Application No. H13/1243/00

PROPOSED DETACHED DWELLING.

**H13/1243/00 - Proposed Detached Dwelling, No.1 High Street, Moulton
for Messrs J, N, & T Barnett**

Proposed detached dwelling, 1 High Street, Moulton – J N & T Barnett.

SITE LAYOUT

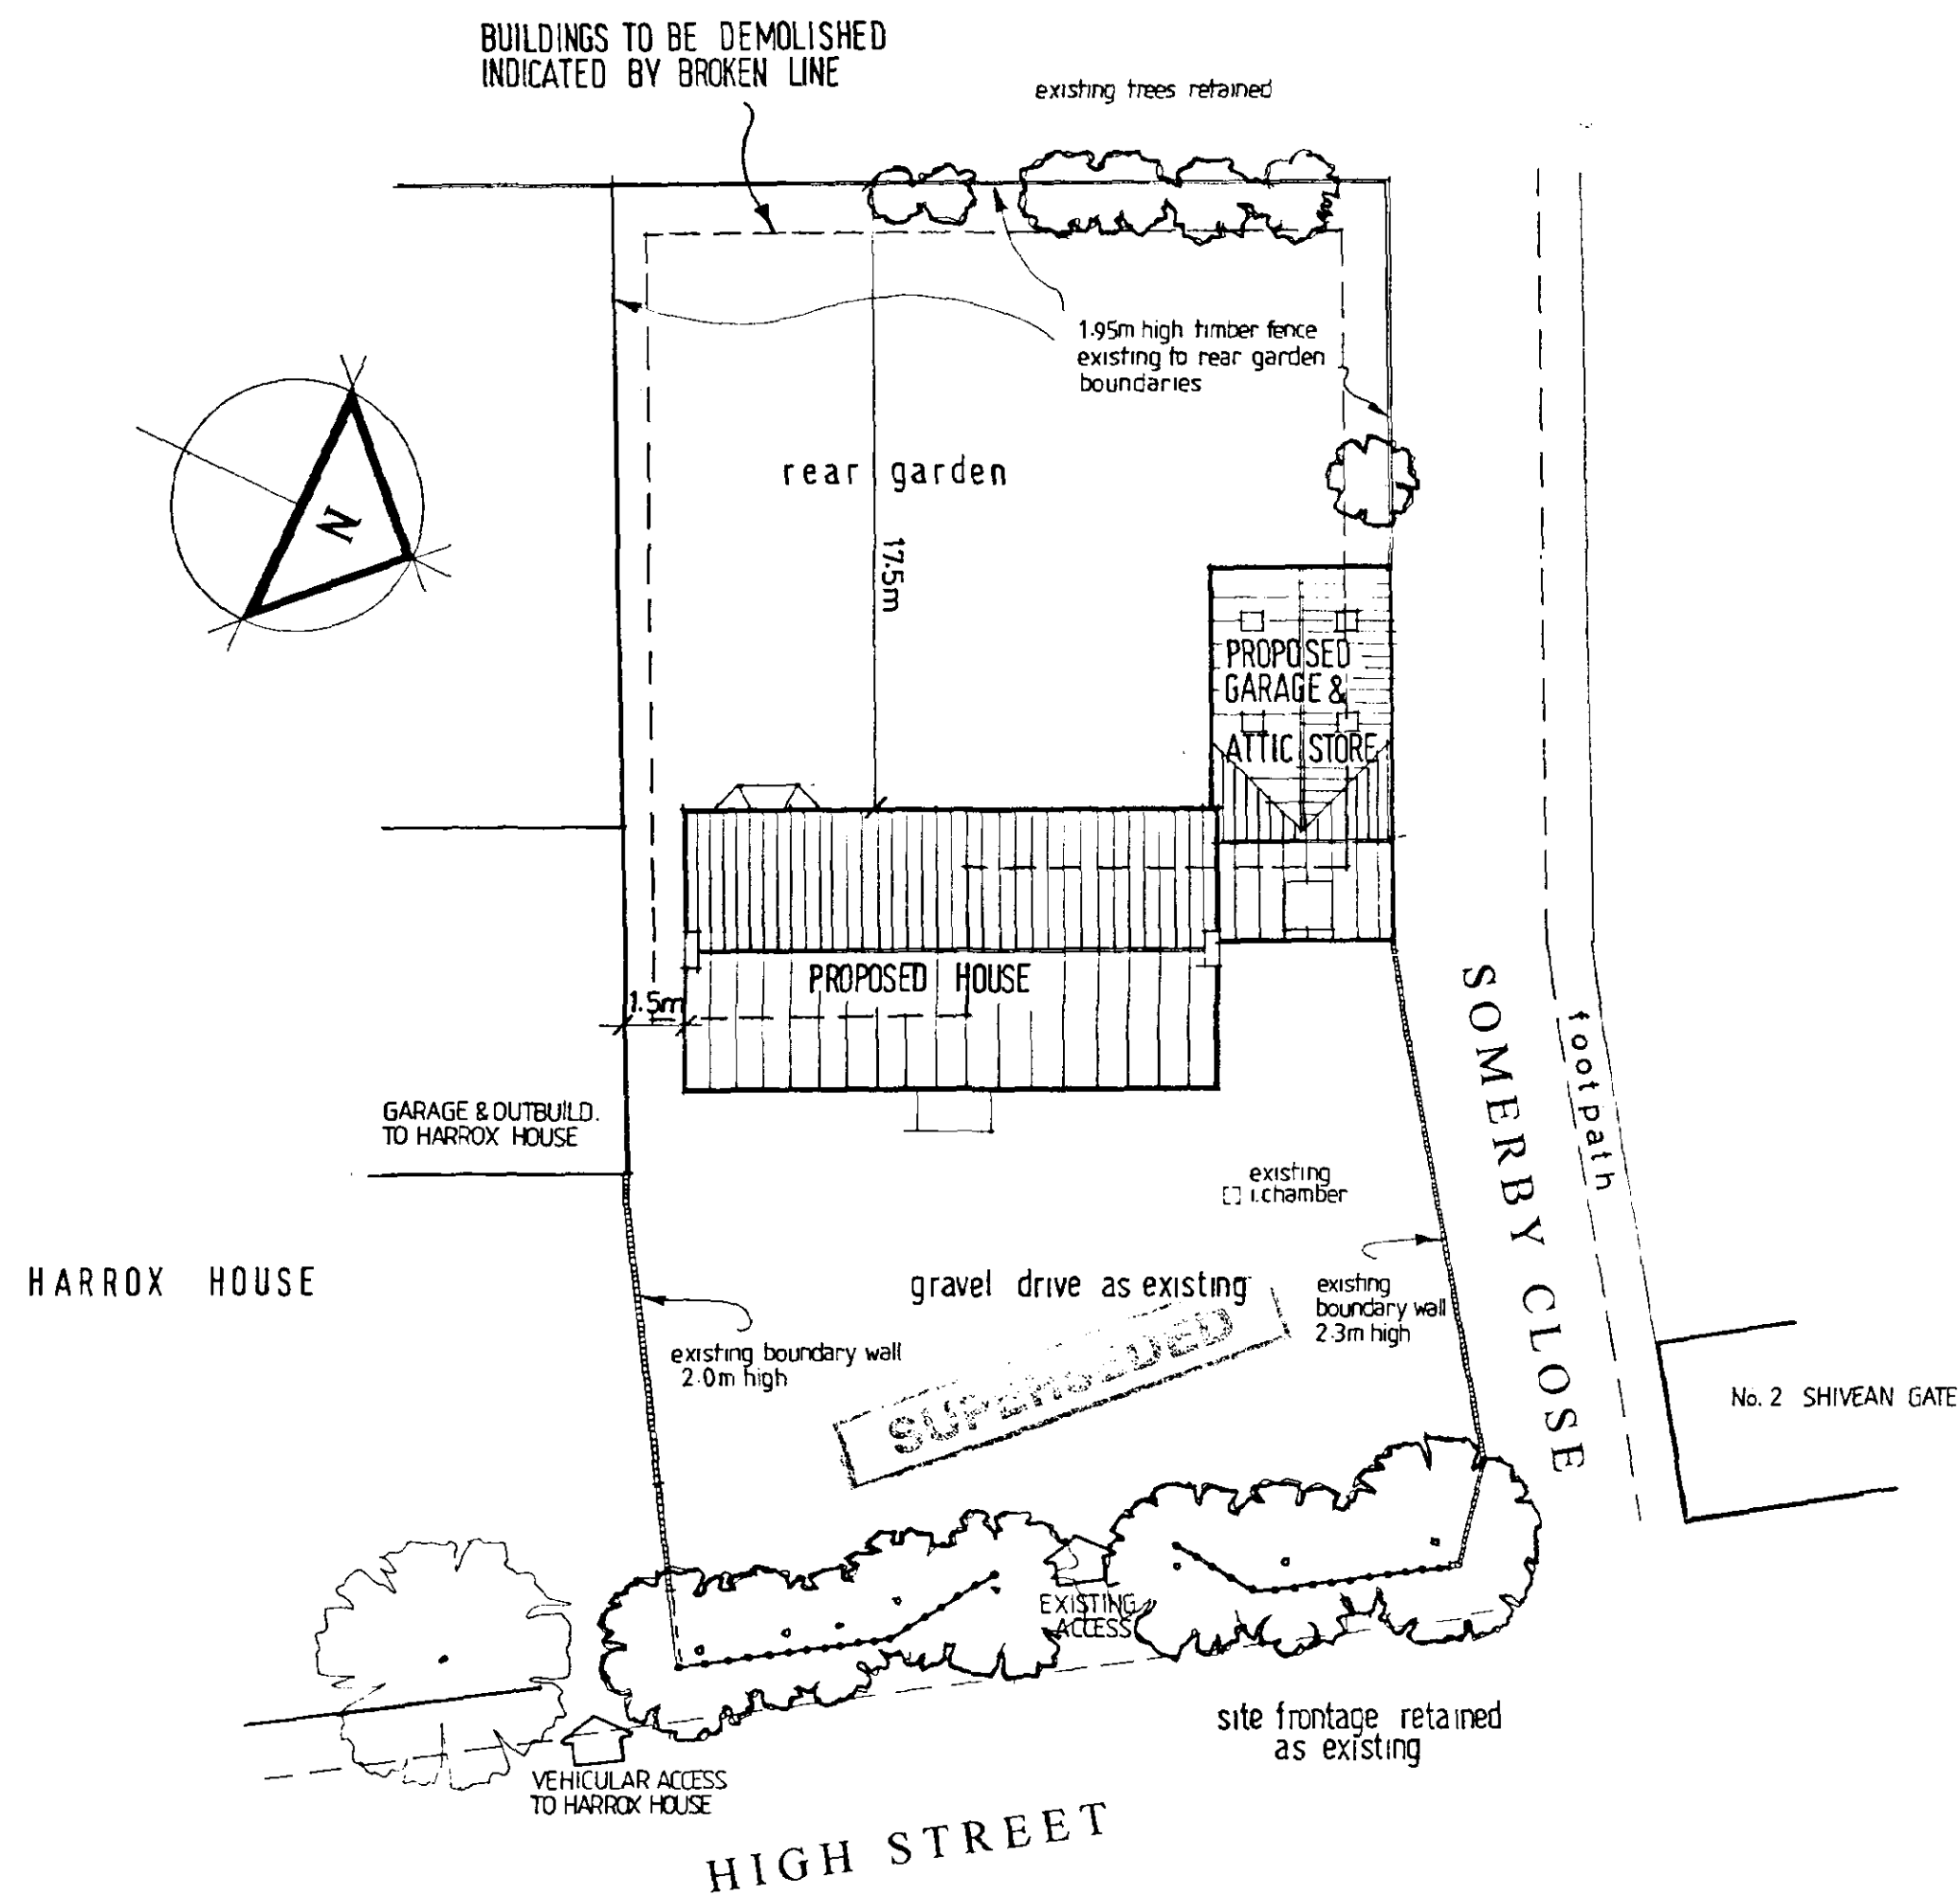
Reduced area of gravel driveway on
frontage.

- a) 4 copies of amended 1:200 site layout plans reducing the extent of gravel drive within the front garden.
- b) Confirmation that the new doors and windows will be timber, with the latter painted white.
- c) Confirmation that the existing trees upon the site (including the Yew trees along the frontage) will be retained in their entirety.

I enclose 4 copies of drg. no. 001001/01a which reduces the area of gravel driveway to the frontage of the proposed dwelling.

A note has been added to the submitted drawing to clarify that all existing trees on the application site are to be retained in their entirety as requested.
